Appeal Decision

Appeal Ref: APP/R5510/D/22/3303747

41 Colne Avenue, West Drayton UB7 7AL

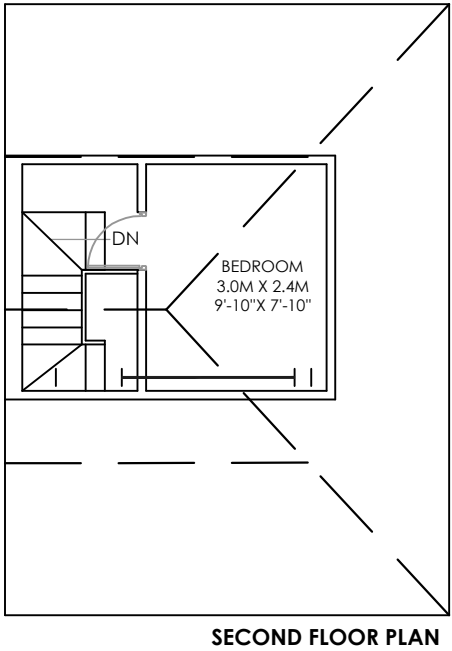
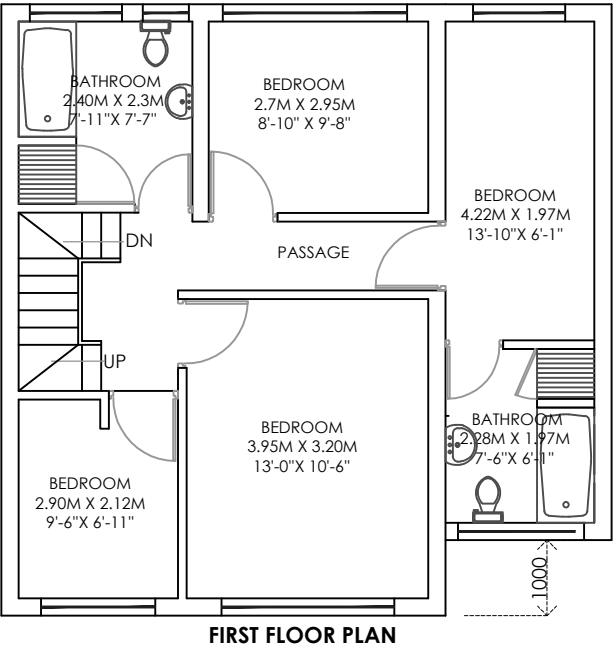
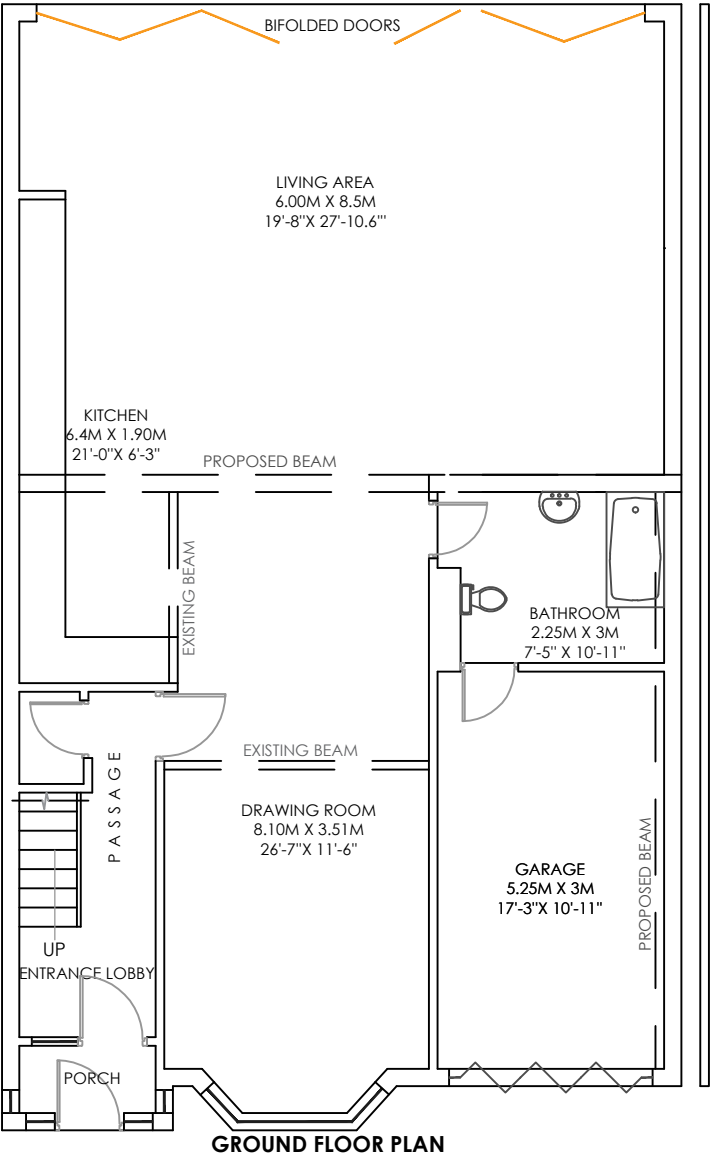
2. There was a discrepancy between the floor plan and elevation plan submitted with the application with the depth of the rear extension being 7.2m on the elevation but 6m on the floor plan. The appellant has confirmed that this was an error and has submitted a corrected elevation plan with the appeal to align with the floor plan. As the floor plan clearly annotated the depth at 6m, I am satisfied that no party has been prejudiced by the correction of the elevation plan in the appeal process.

6. The proposed side extension would be forward of the front façade of No 43. As such, even with a 1m gap at the first floor, due to the forward positioning of the host dwelling, the proposal would appear very tight in relation to No 43. In this regard, the proposal would appear cramped in the street scene.

10. The neighbouring property at No 43 has a small side bedroom window which would face the proposed first floor extension. The Council has not referred me to any local definition of a habitable room. However, the London Plan (2021) defines a habitable room in its Glossary as any room used or intended to be used for sleeping, cooking, living or eating purposes. In this regard, the bedroom would constitute a habitable room.
11. The appellant advises that the side window is a secondary window, with the front much larger window providing the main outlook and light into the room. However, the Council dispute this, and advise that a partition wall has been installed creating a bedroom with the side window being the only source of

12. At 1m to the boundary, the proposed side extension would be a dominant built form from this window and would likely result in a reduction in natural light within the room. I have no technical evidence before me to quantify the level of light within the room. However, at such close proximity, the level of change in both outlook and natural light would, in my view, be significantly harmful.

14. The single storey rear extension would stretch across the full width of the host dwelling and would therefore be visible from both neighbouring properties either side. However, it would be single storey with a flat roof and despite its projection to the rear, it would not therefore be unduly dominant or obtrusive at the height proposed. Moreover, as the attached dwelling has an existing rear extension and as No 43 is positioned further back than the host property, the proposed rear projection would not result in an undue sense of enclosure to either neighbour. Overall, given its distinctly low profile, it would not create an oppressive outlook from either of the neighbouring properties or their respective rear gardens. This does not, however, overcome my concerns regarding the effects from the side extension.

Proposed Elevations

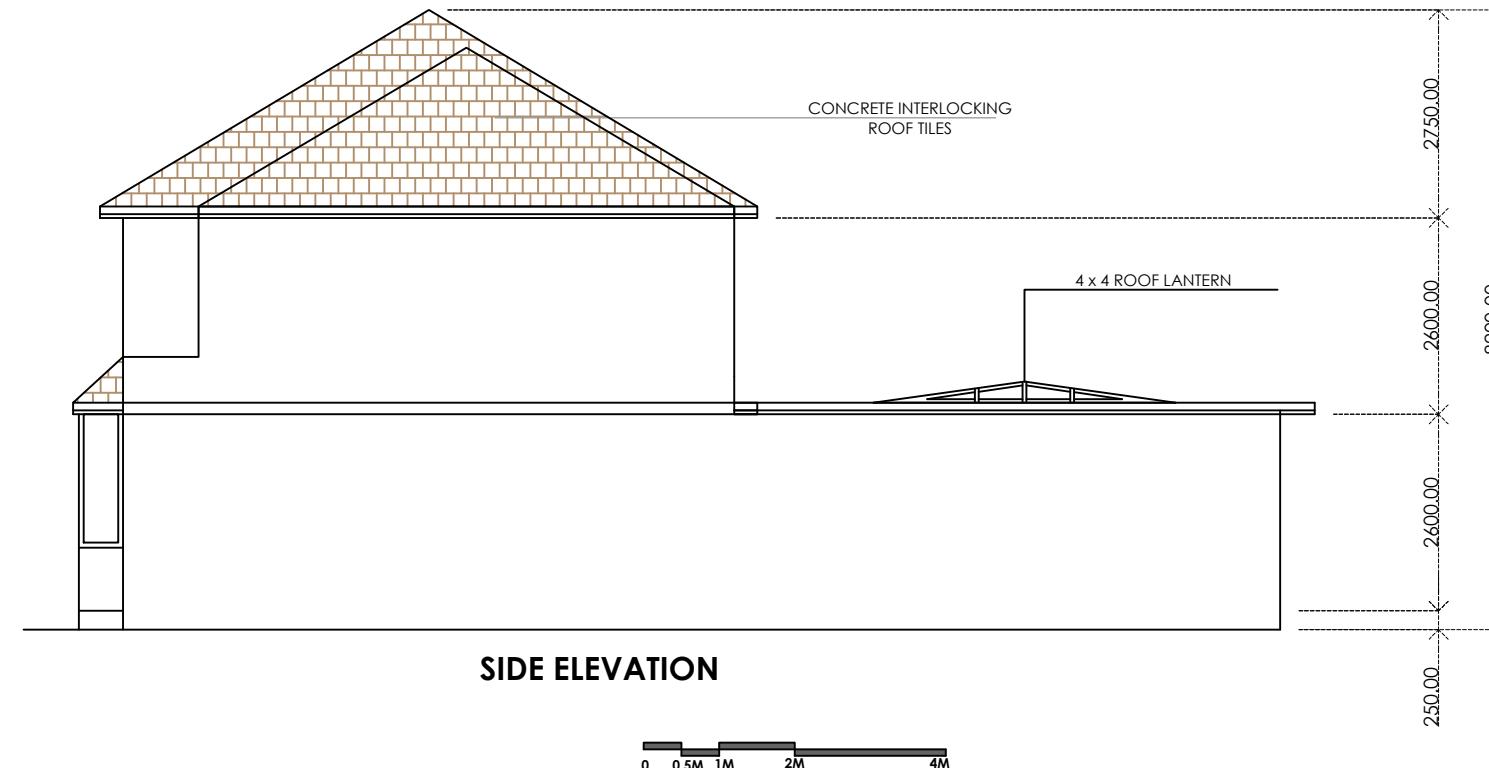
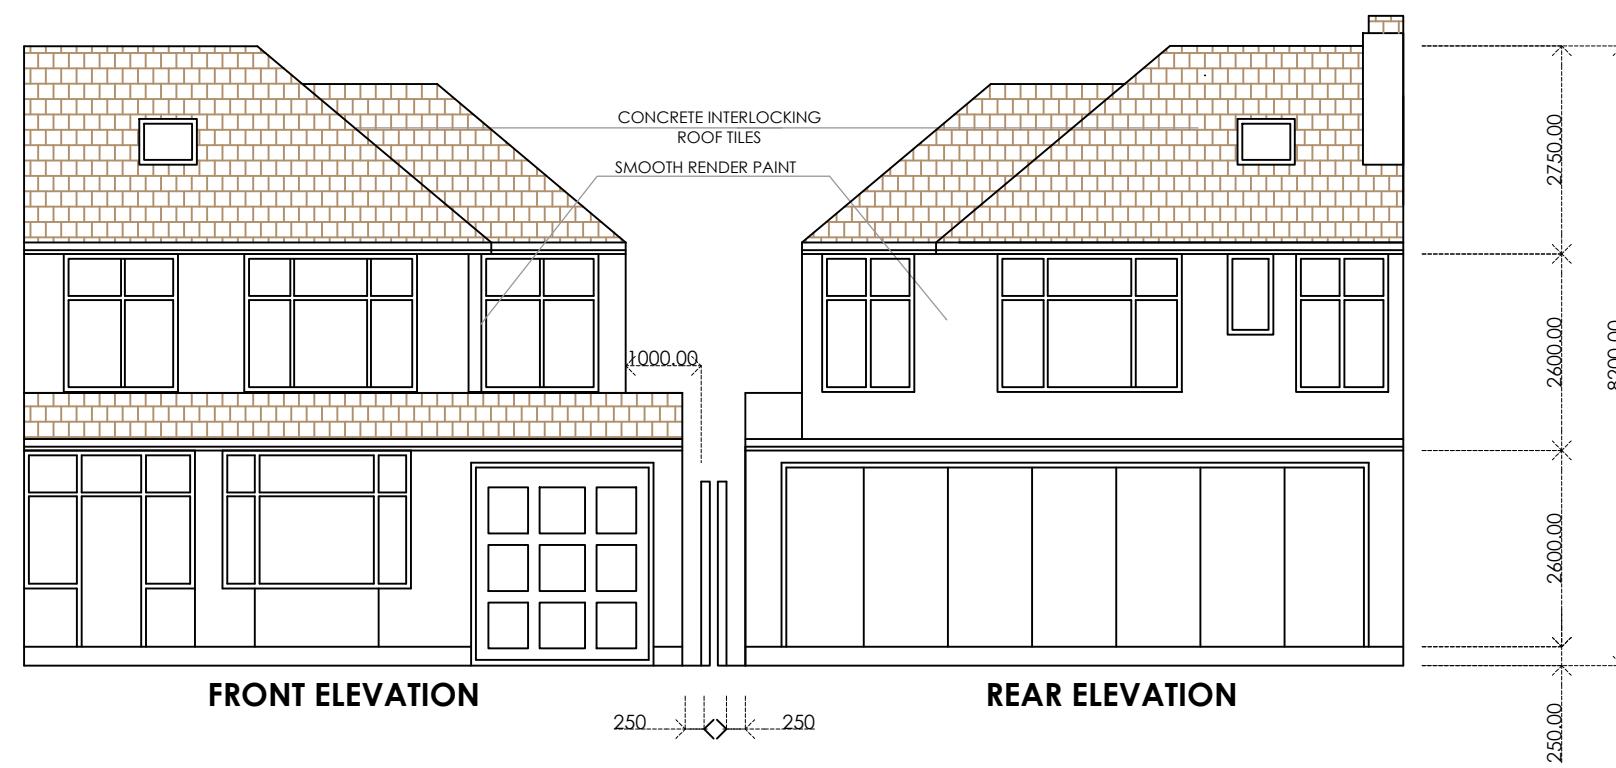
7. The rear extension would be single storey with a flat roof and a small lantern. As such, it would be subservient in height to the host dwelling. Moreover, whilst it would obscure all of the original ground floor of the host dwelling, the first floor and roof structure of the original property would remain entirely visible.
